From: Bruce Taunton
Sent: 19 November 2013 12:59
To: Planning.Responses
Subject: RE: Planning Consultation on: WA/42/13/

APPLICATION WA/42/13/

Site Address: Slate Barn Farm Binsted Lane Binsted BN18 0LQ

Description of Works: Conversion of redundant farm building into family guest accommodation.

proposed SECTION A - A

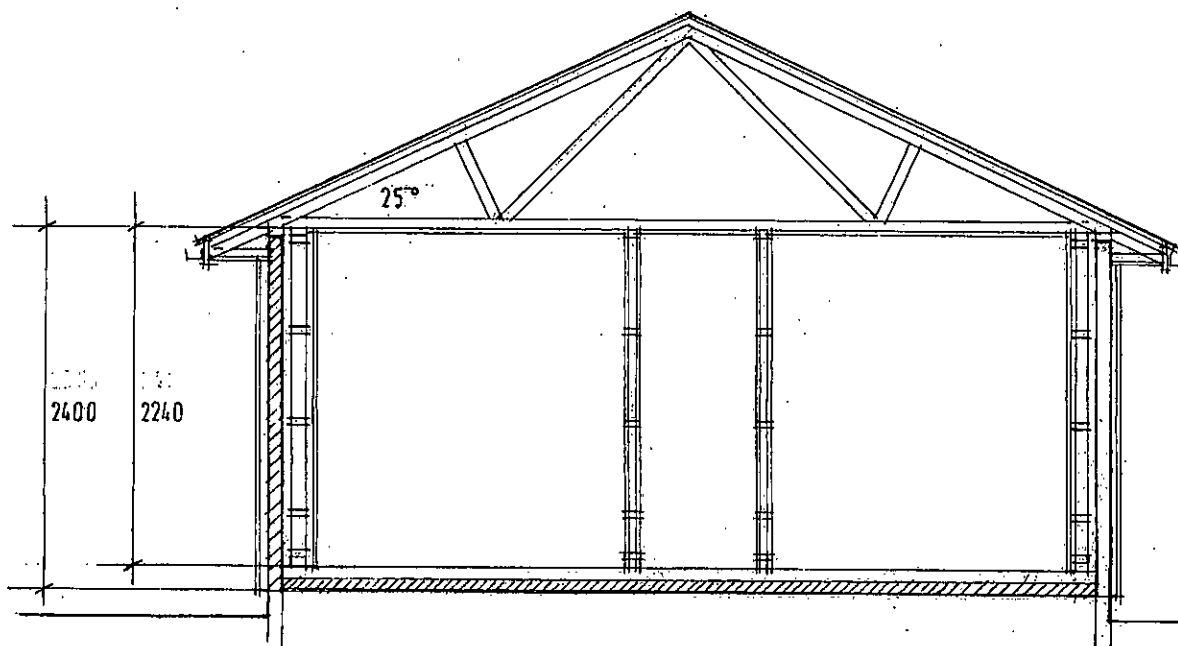
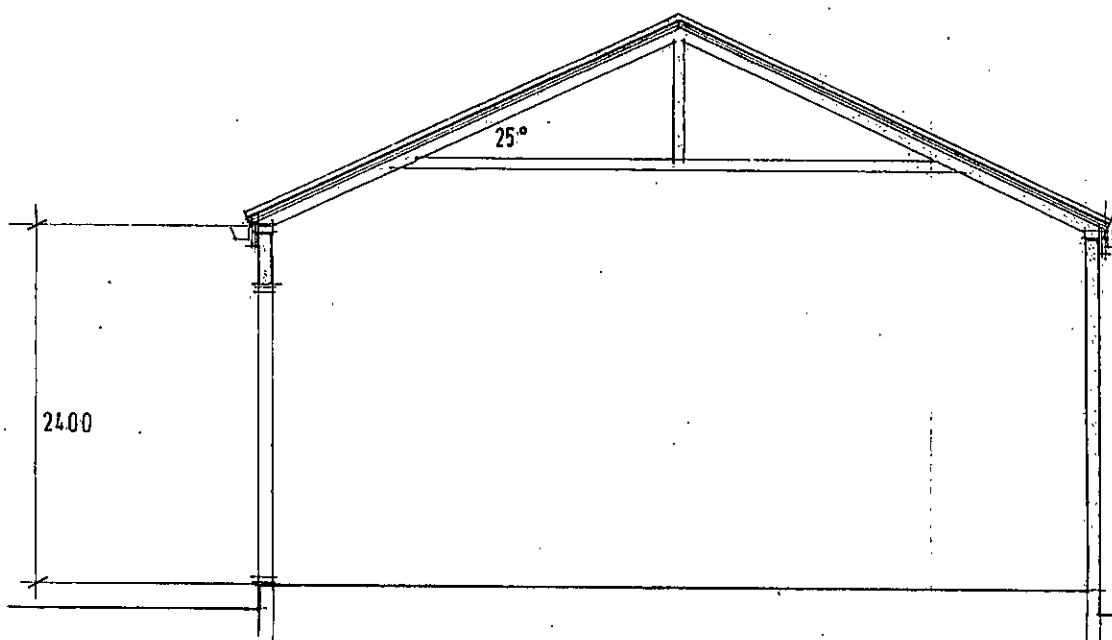
Having viewed the application, in the absence of a structural engineers report please apply standard condition ENGS2. Furthermore justification of the adequacy of the walls and foundations to support increased load from the new roof covering is needed.
